1 Barrack Lane, 81-83 George Street Build-to-Rent Development (SSD-79439459): Response to Submissions – Heritage

This letter has been prepared to respond to the RTS themes broadly and specifically submitted by agencies and City of Parramatta Council as outlined in the key issues letter by the Department of Planning, Housing and Infrastructure, dated 24 December 2025. It addresses both built heritage and archaeological issues.

SHR CURTILAGE

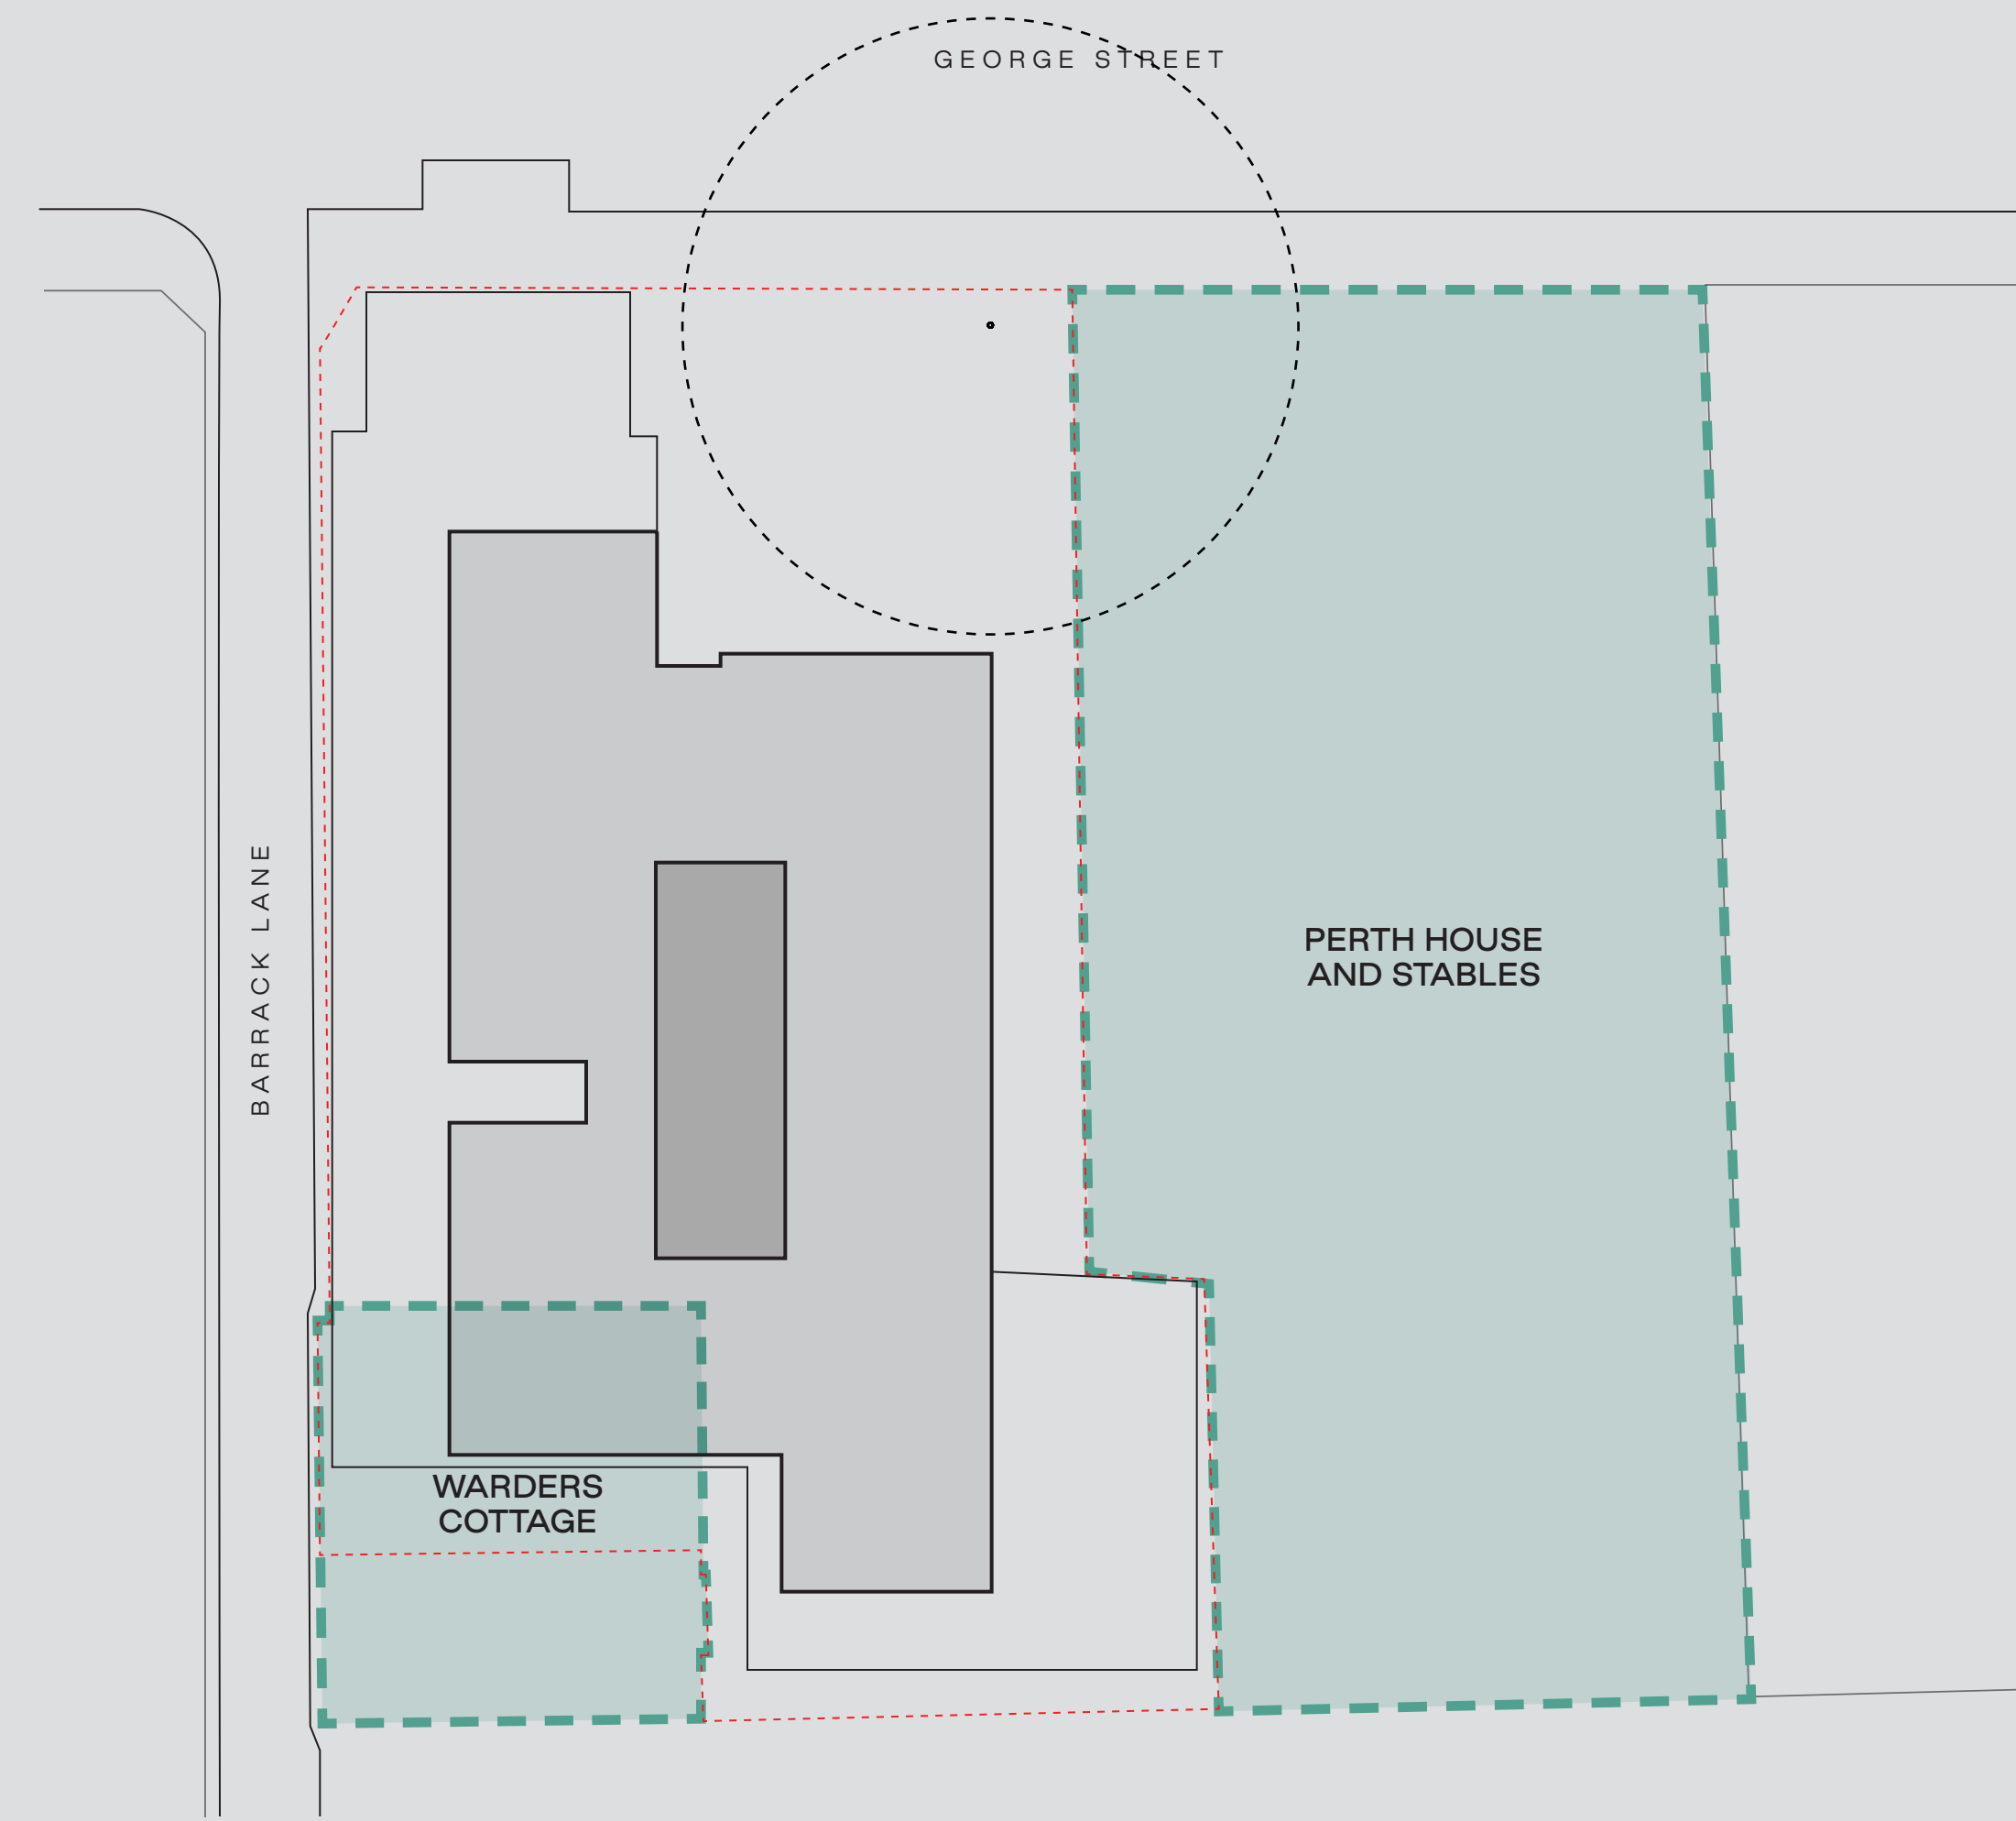
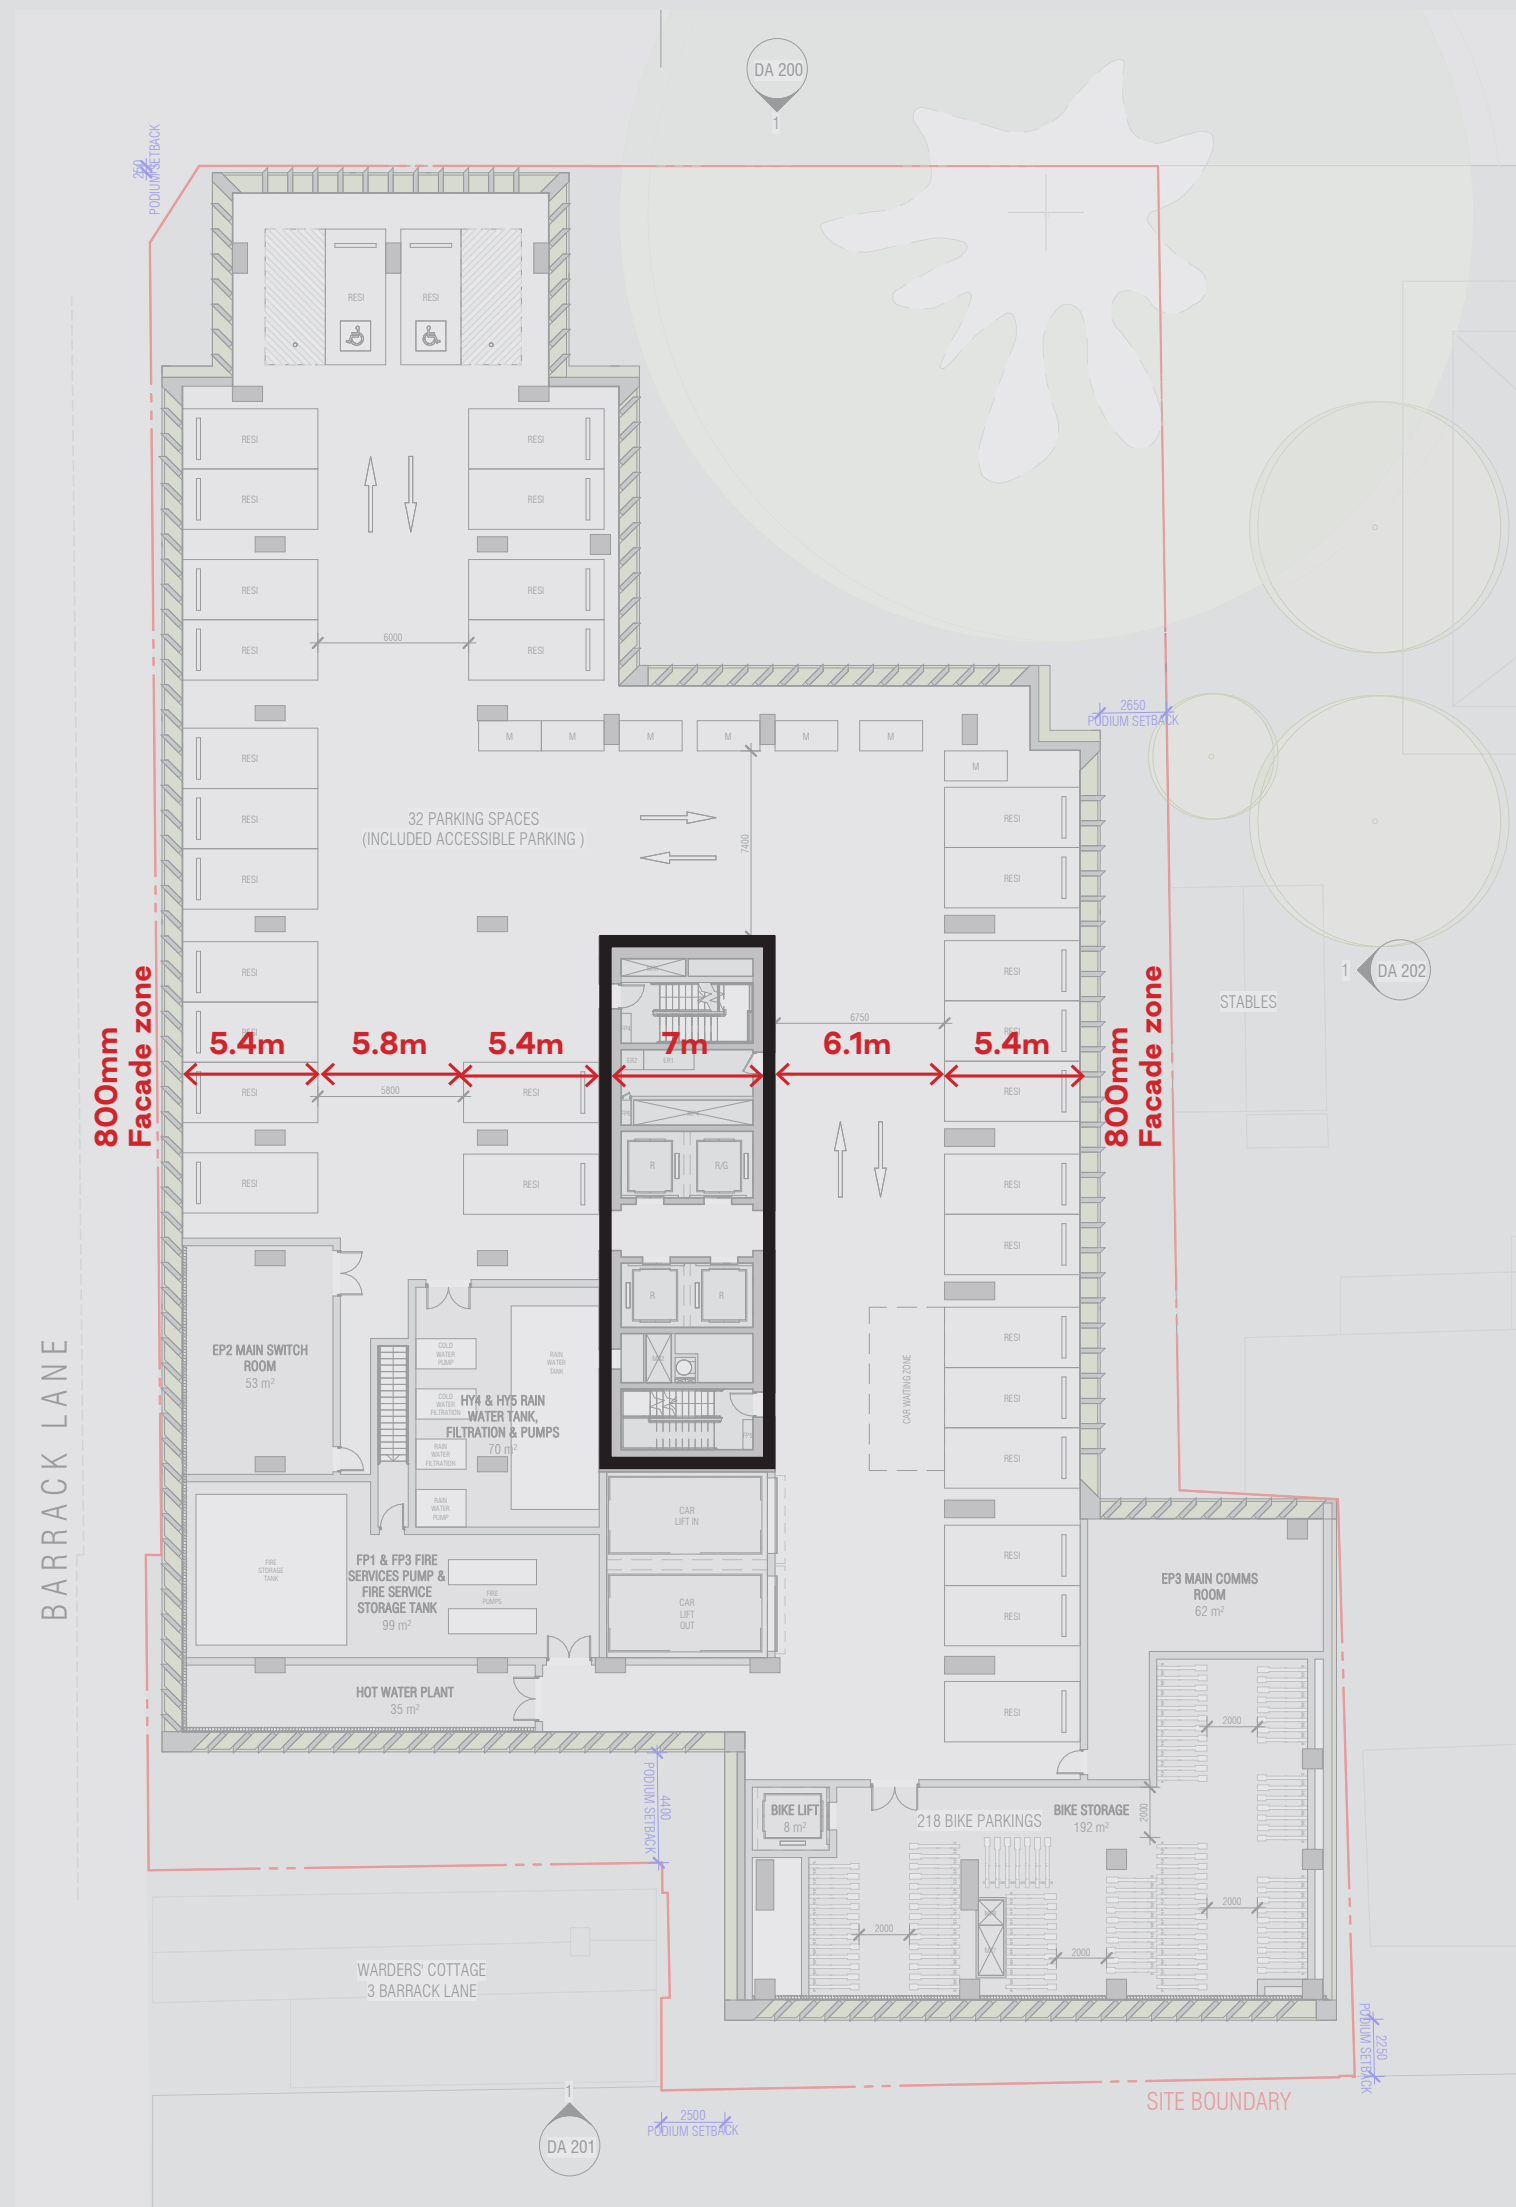
The State Heritage Register curtilage for the Warders Cottages (State heritage item 00709), includes the heritage cottage row at 3 Barrack Lane and the three-storey commercial building (constructed between 1987 and 1991) at 1 Barrack Lane. The subject site includes the commercial building at 1 Barrack Lane but excludes the Warders Cottages at 1 Barrack Lane.

Within the SHR curtilage of the Warders Cottages at the Ground Floor level, the proposal has provided a considered response by providing a generous setback at ground level, which would allow flexibility for future uses and activation of the Warders Cottages. In this way, the proposal has focused on improving the setting through activating the interface with the Warders Cottages, which is currently defined as a utility zone surrounded on all sides by vehicle entries, parking and loading bays.

Item Ref.	Summary of Matters Raised	Response
		Within the SHR curtilage of the Warders Cottages above the Ground Floor plane, new built form development is proposed. The massing of the development is broken down with the creation of the 3-storey podium and separate tower form, in which pedestrian views would be contained within the lower scale components. The overhang of the podium within the curtilage of the Warders Cottages contributes to the establishment of an intimate and contained outdoor space that is of a compatible scale to the heritage building and as a result of the establishment of this open space setting, there will be enhanced views both to and from the building. Development within the SHR curtilage of the Warders Cottages is therefore assessed to have an acceptable heritage impact as the proposal will facilitate improvement of the setting and enhanced opportunities for public appreciation of the heritage building.
